Date: 08 October 2018
Our ref: 257635
Your ref: TR020002

**NSIP Reference Name / Code: Manston Airport / Planning Inspectorate Reference TR020002
Natural England's Relevant Representations in respect of Manston Airport**

- 1.5. Natural England's advice in these relevant representations is based on information submitted by RiverOak Strategic Partners Limited in support of its application for a Development Consent Order ('DCO') in relation to Manston Airport. The project refers to the upgrading and re-opening of Manston, primarily as a cargo airport, with some passenger services, with a capacity of at least 10,000 air cargo movements per year.

Title ENVIRONMENTAL FEATURES -
 STATUTORY OR NON-STATUTORY
 SITES OR FEATURES OF NATURE
 CONSERVATION PLANS
 REGULATION 5(2)(1)(i)
 SHEET 5 of 5
 THANET DISTRICT COUNCIL

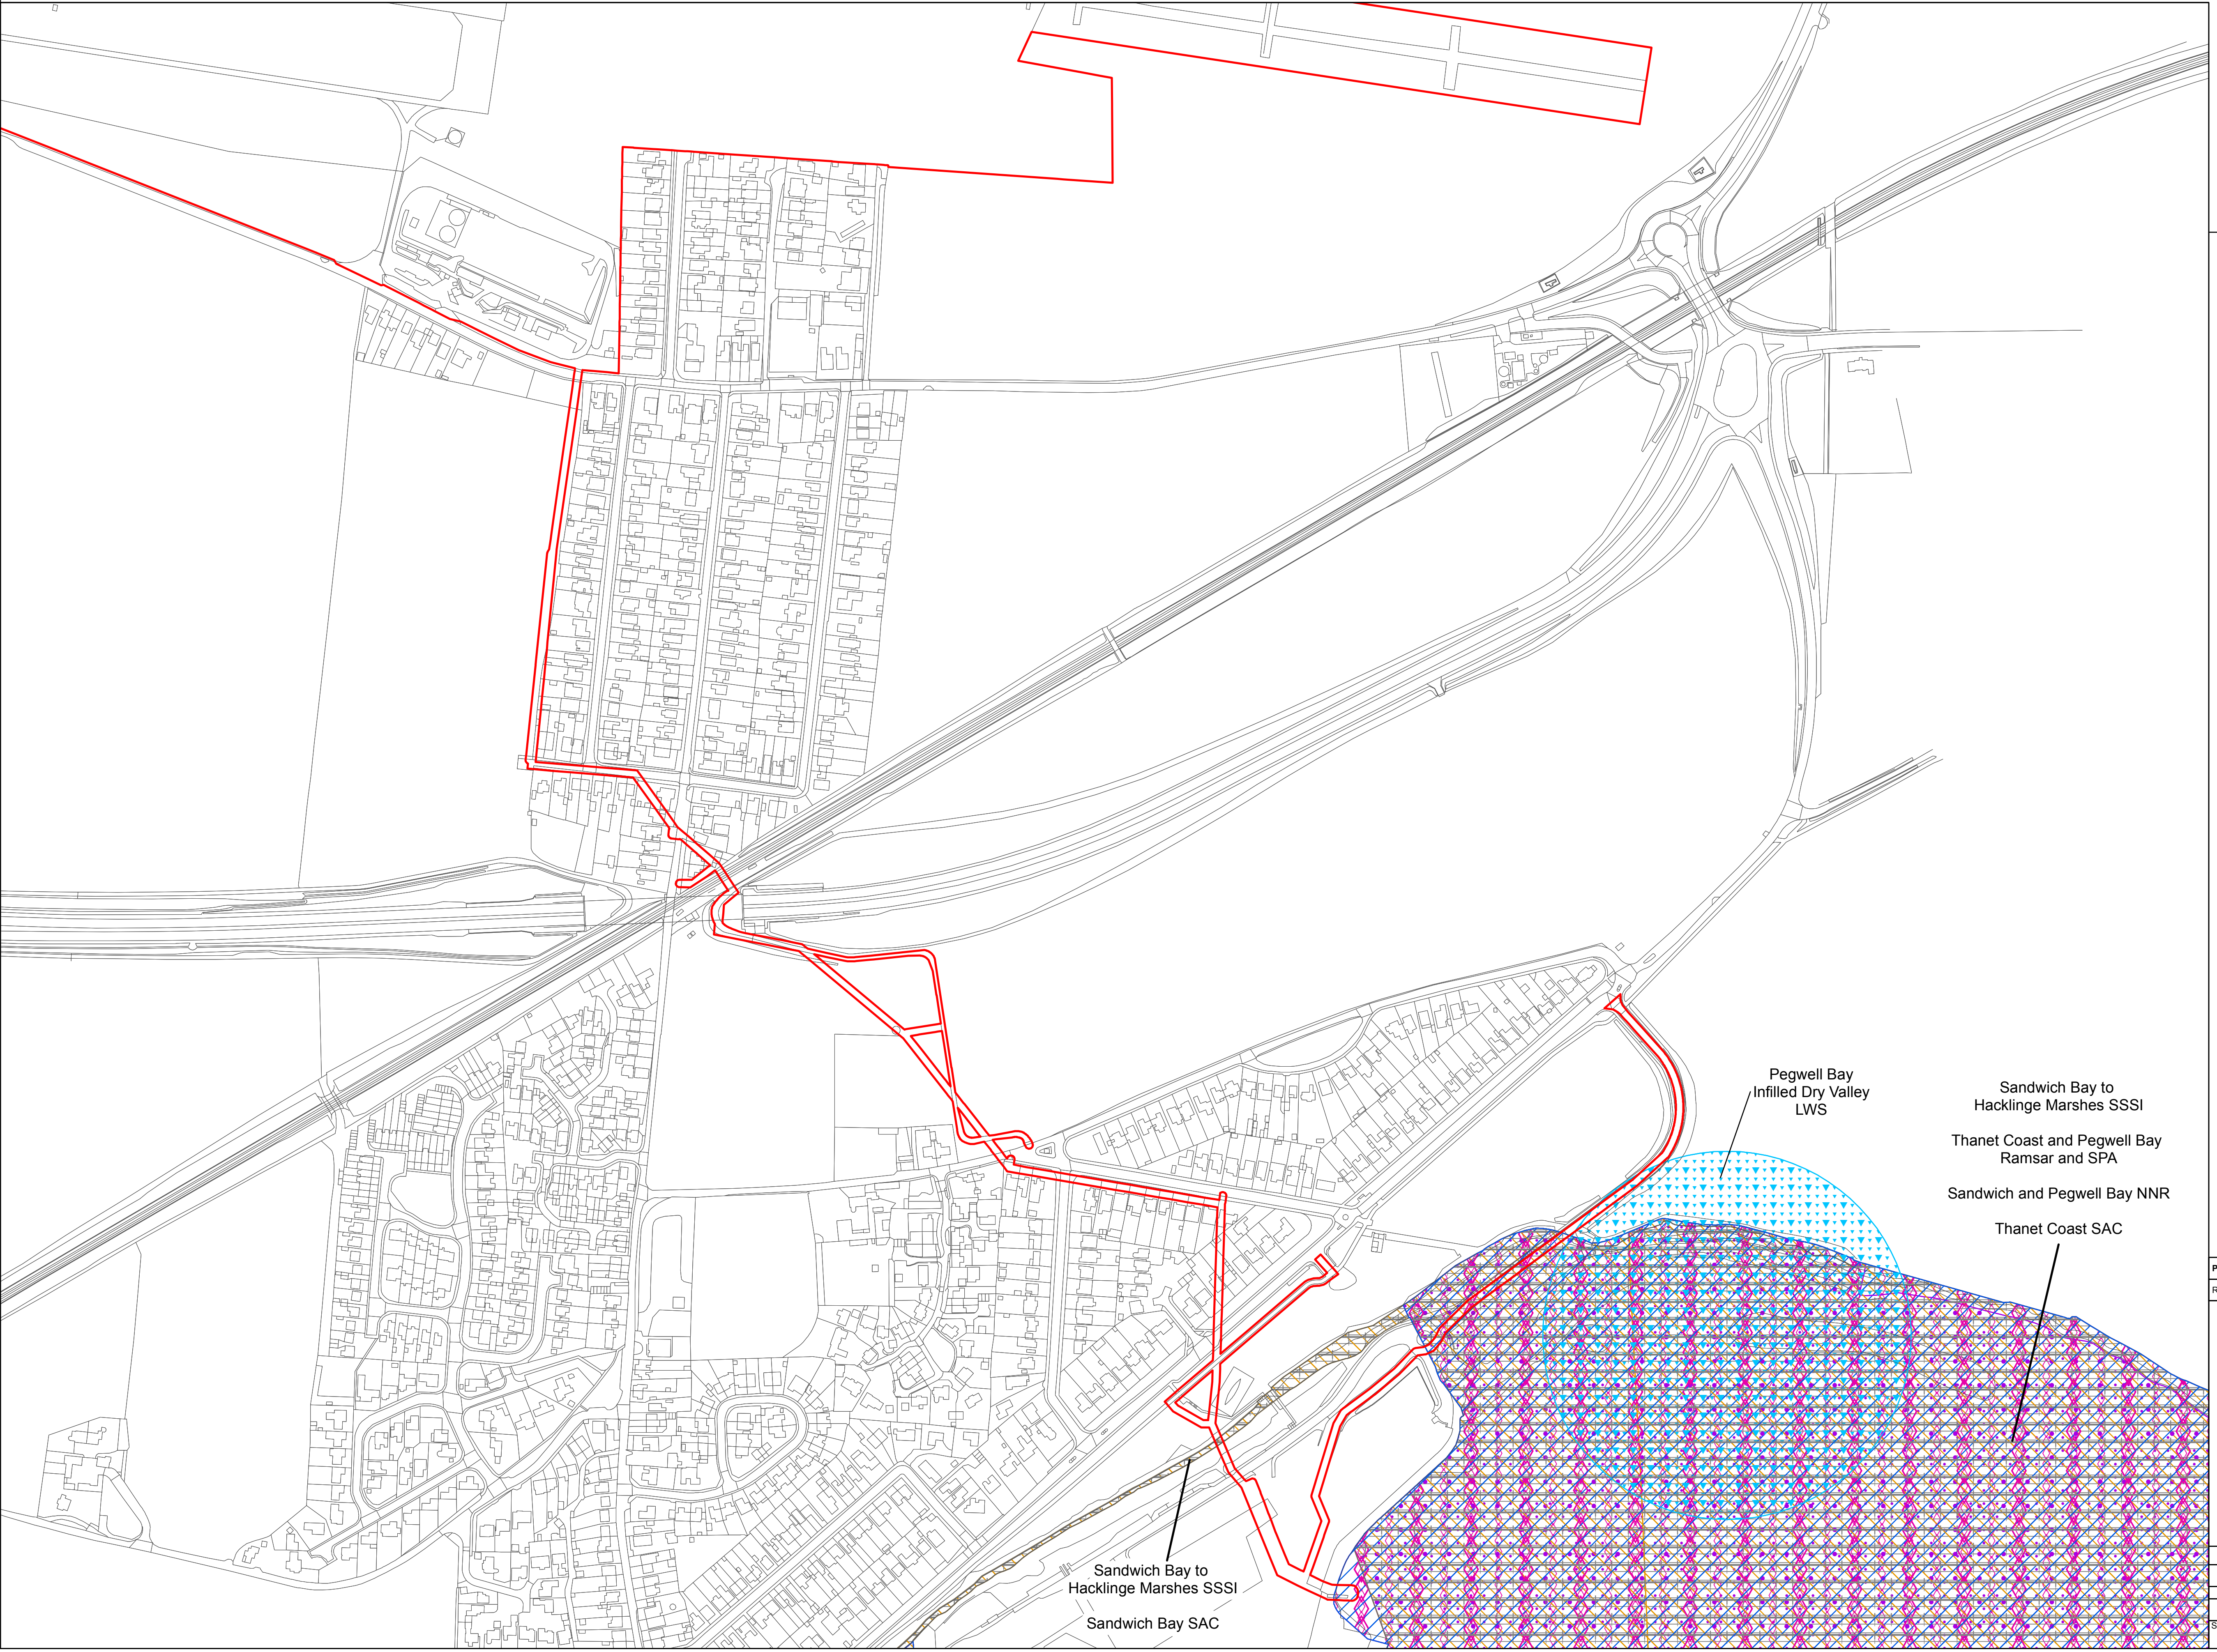
The ES contains details of an outline drainage strategy (DS). The intention at the operational stage is for all surface water to be treated on site and then discharged via an existing outfall into Pegwell Bay. Based on Figure 1.1 (ES Vol 4) it is clear that the outfall lies within the boundary of a number of designated nature conservation sites. However, the Biodiversity chapter (ES Vol 1, Chapter 7) is unclear exactly which designated sites and relevant interest features have the potential to be affected by the surface water outfall. References to 'the Pegwell Bay designated sites' are not sufficient. It is clear that the detailed design of the drainage strategy is not intended to come until after DCO consent at which point the applicant 'may' need to apply for a new discharge permit from the Environment Agency (EA) (ES Vol 1, Chapter 3, Para 3.3.74). However ES Vol 1, Chapter 7, Table 7.7 states on the same issue that 'Discharge from these ponds *will be* via a permitted discharge to Pegwell Bay.' (our emphasis). ES Vol 1, Chapter 8, Table 8.6 summarises the applicant's discussions to date with the EA. The most recent position appears to be that as the discharge to the Pegwell Bay outfall would be of surface water it would not normally require a permit. One possible solution would be for a discharge permit to control the quality of the discharge from the contaminated pond to the clean pond. Given that the DS is an outline, that there is apparent ambiguity over whether the surface water discharge during operation will be controlled by a permit and the current lack of clarity over the designated site interest features which could potentially be affected, Natural England considers it premature at this stage for the applicant to conclude that there will be no significant impacts on internationally or nationally designated sites as a result of the surface water discharge.

- A clear list of the designated sites and relevant interest features which have the potential to be affected by the surface water outfall. What type of habitat surrounds the outfall?
- Clarification as to how the EA's permitting regime will apply to the surface water discharge.
